From: Nick Howard
Sent: 02 September 2019 17:52
To: Planning.Responses <Planning.Responses@arun.gov.uk>
Subject: RE: Planning Consultation on: WA/76/19/PL

Kitchen Ventilation Extract System

Registered: 20th August
2019
Site Address: Walberton Place Care Home Yapton Lane Walberton BN18 0AS
Grid Reference: 497467 105634
Description of Works: Retention of kitchen extract system. This application may affect the character & appearance of the Walberton Village Conservation Area.
I

DRAWING
SECOND FLOOR PLAN

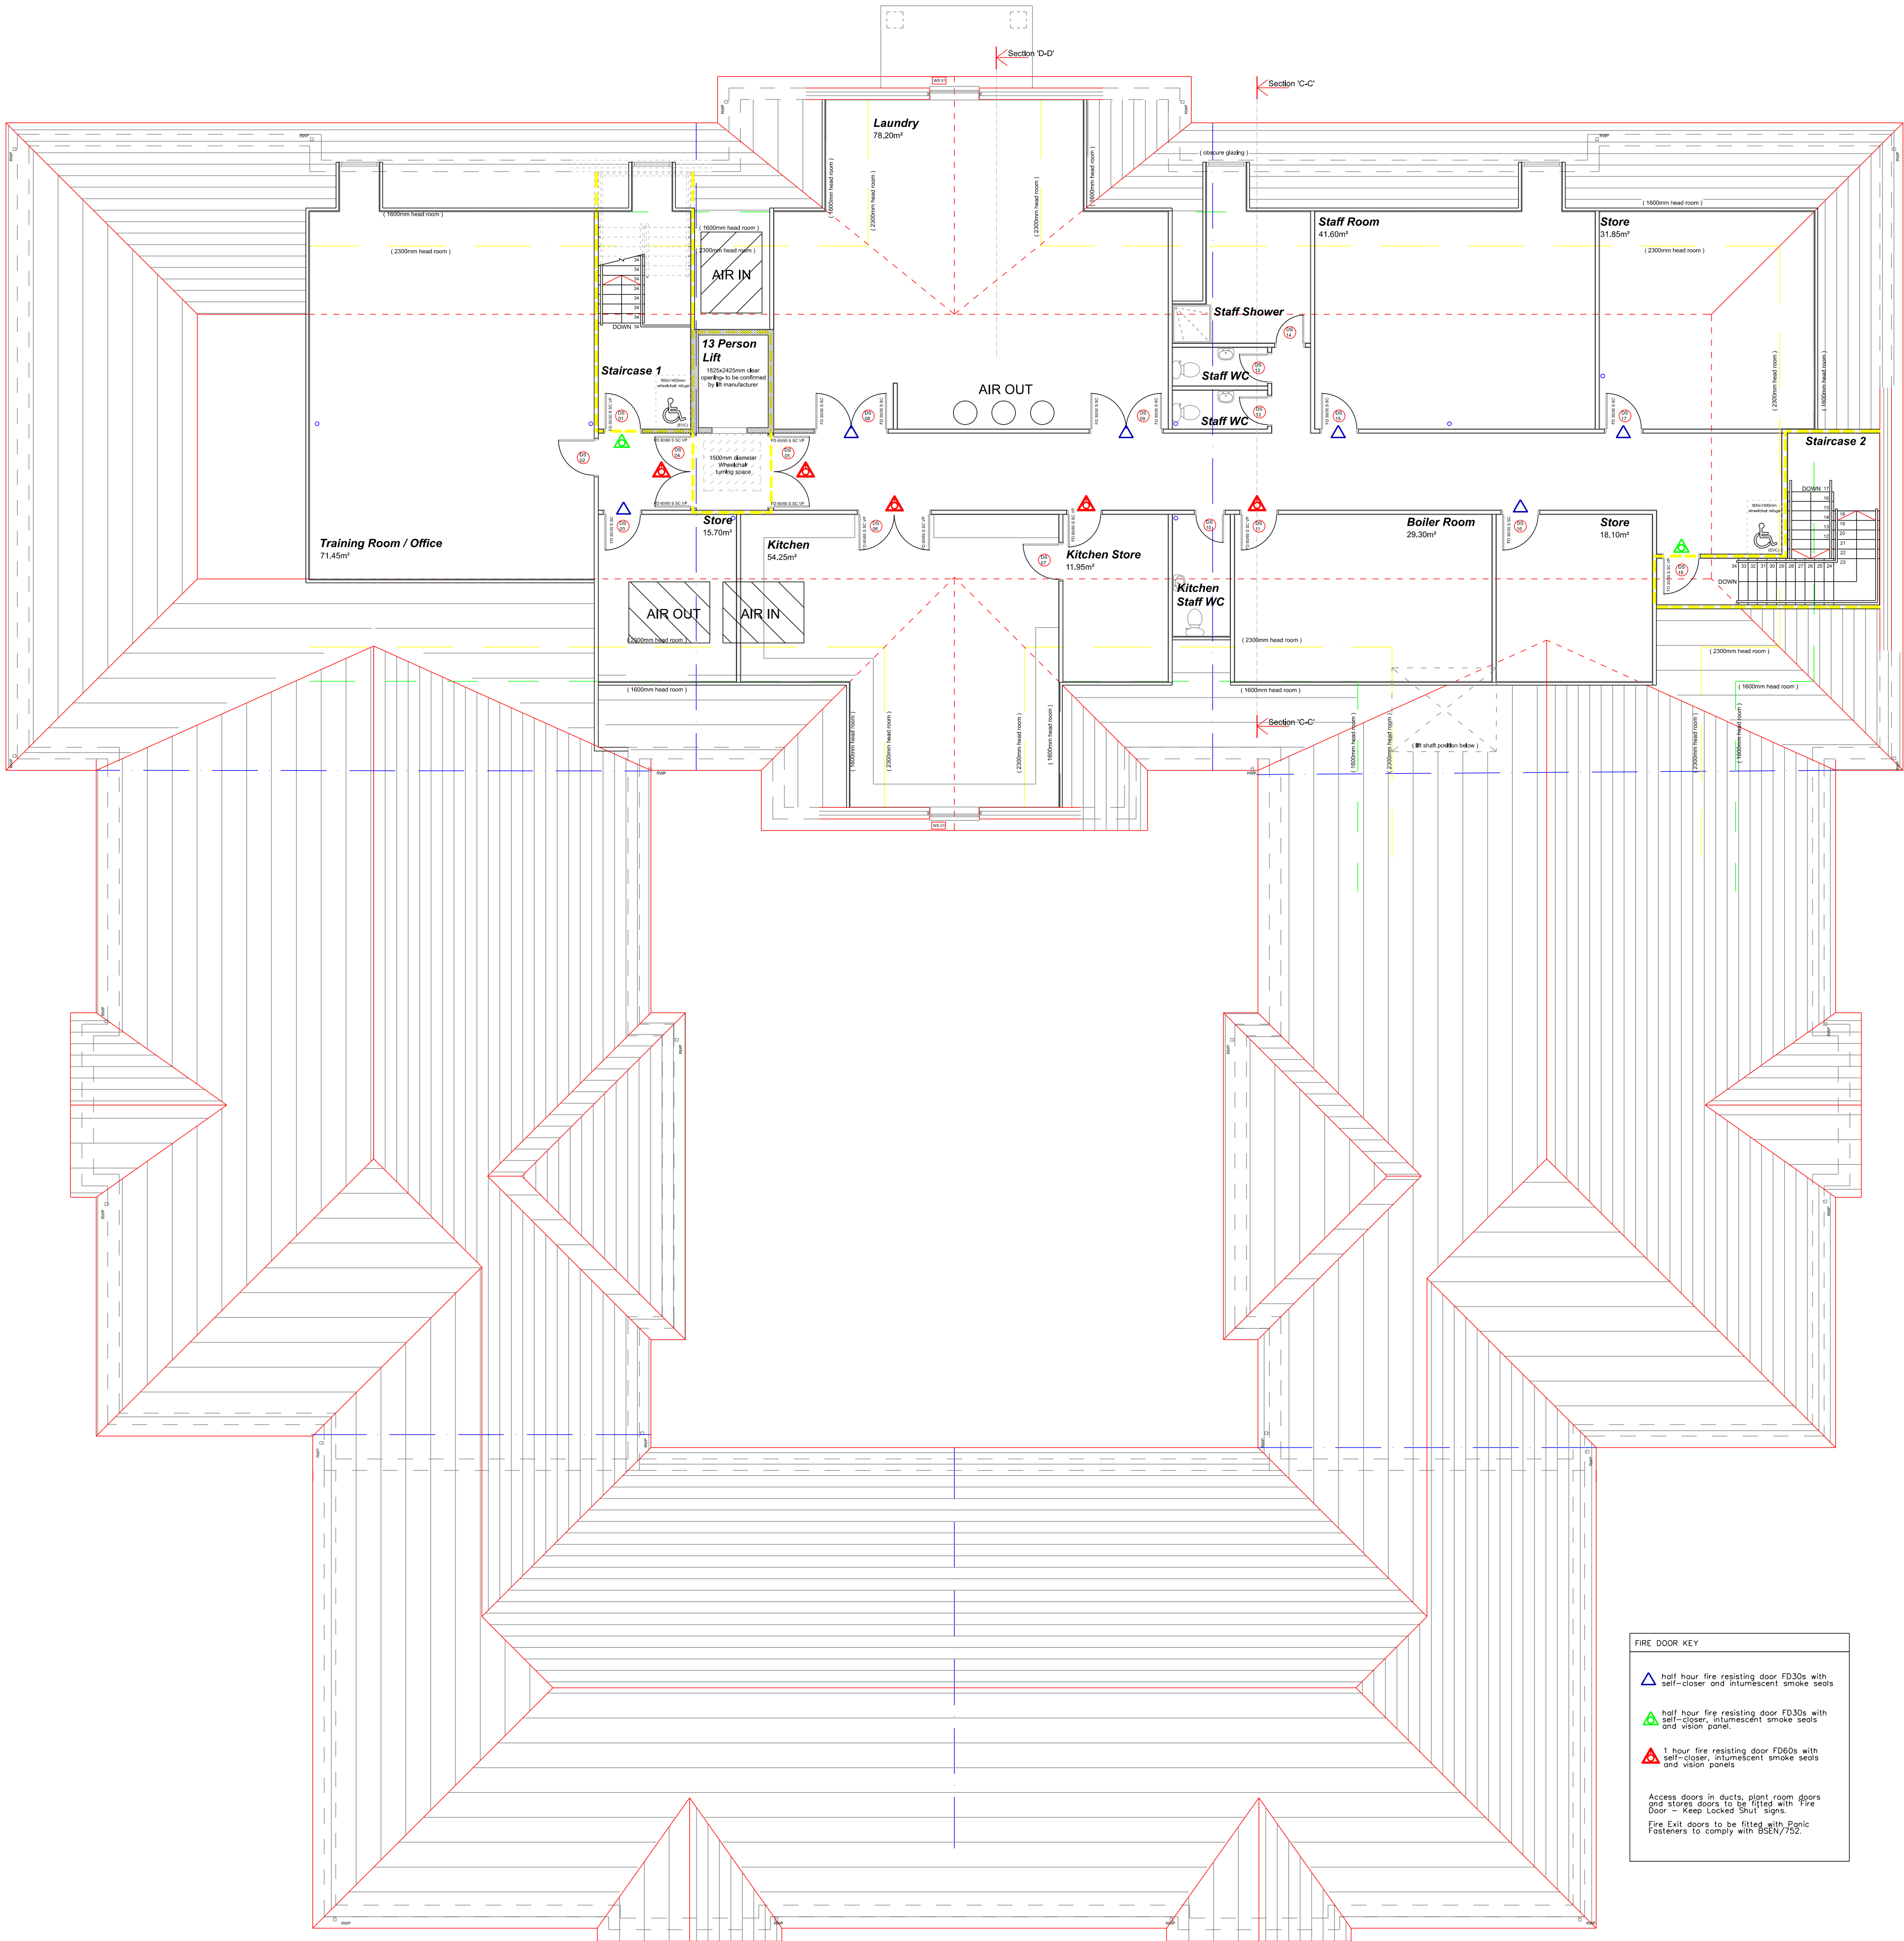
I noted on the application there was little information provided on the system for me to fully assess its effectiveness. Therefore the use hereby permitted should not be carried on unless and until details of a suitable system for the extraction of cooking odours (including details and drawings/sketches of the extract fan units, filters, extraction hoods and ducting together with method of noise abatement) has been submitted to and approved in writing by the Local Planning Authority.
